Proposal: Shop top housing development with in-fill affordable housing
Property: 79-81 Queens Road and 2-8 Spencer Street, Five Dock
Ref: SSD-78287462

The City of Canada Bay has reviewed the EIS and supporting documentation and objects to the application in its current form due to several concerns, which are outlined below.

Figure 6: Level 1 floor plan (Plus Studio, 2026)

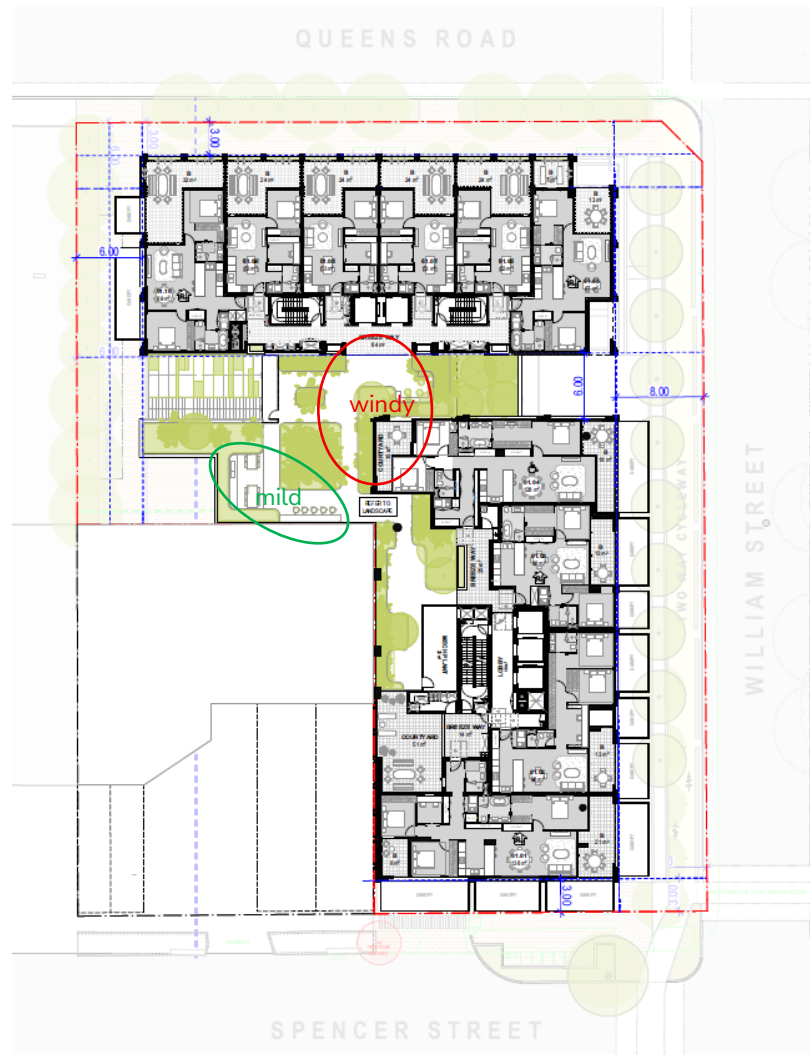
In particular, the location of the proposed driveway directly along the boundary may constrain future access, integration, and redevelopment opportunities for 10–12 Spencer Street. In addition, the communal open space proposed at Level 1 has the potential to generate amenity impacts, such as overlooking and noise, on any future residential development of that site.

The siting of communal open space at the podium level 1 and 5 along the boundary further exacerbates impacts, introducing potential overlooking and privacy concerns for any future residential development on 10–12 Spencer Street.
